Figure 5.1: Maximum Parking Accumulation, 2016

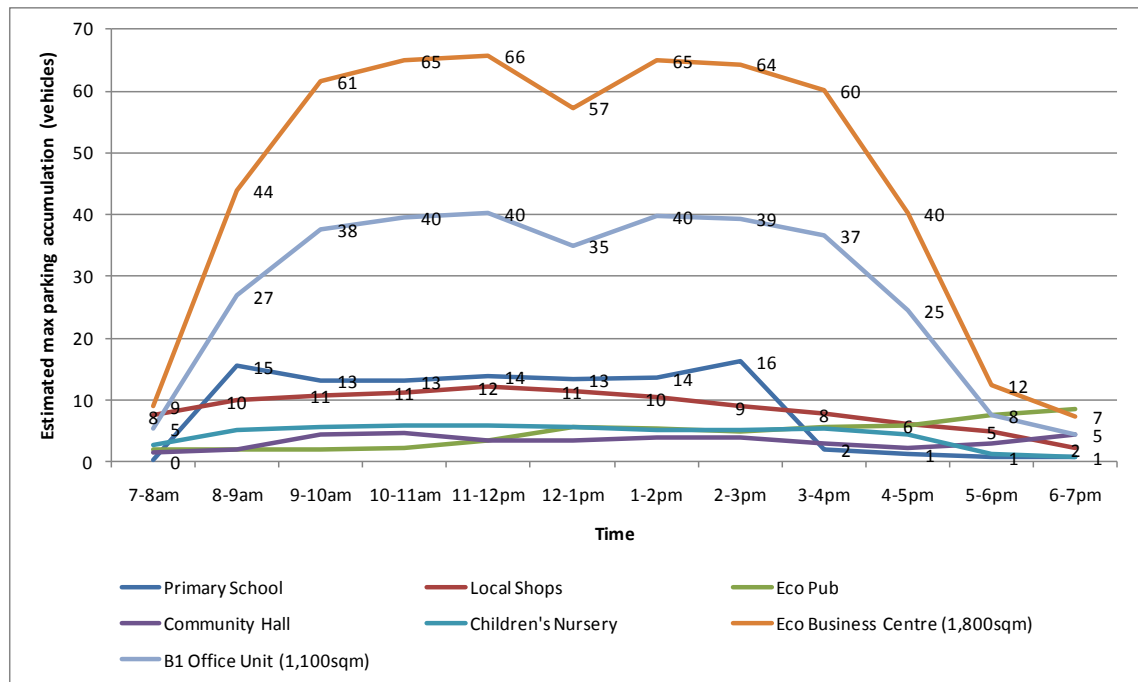
Parking provision – the residential parking levels appear to be as they would be for any standard development and not in-line with an eco-development.

Visitor parking up to 118 - 0.3 spaces per residential unit - this is high for an eco-development. Generally Oxfordshire County Council accepts 1 visitor space for every 4 to 5 units i.e. OCC would accept between 78 - 98 visitor spaces. Visitor spaces need to be designed into the Exemplar layout and in places act as calming features.

We do support low parking provision for non-residential purposes but they need to be justified and it is not shown how they have been calculated - this is required.
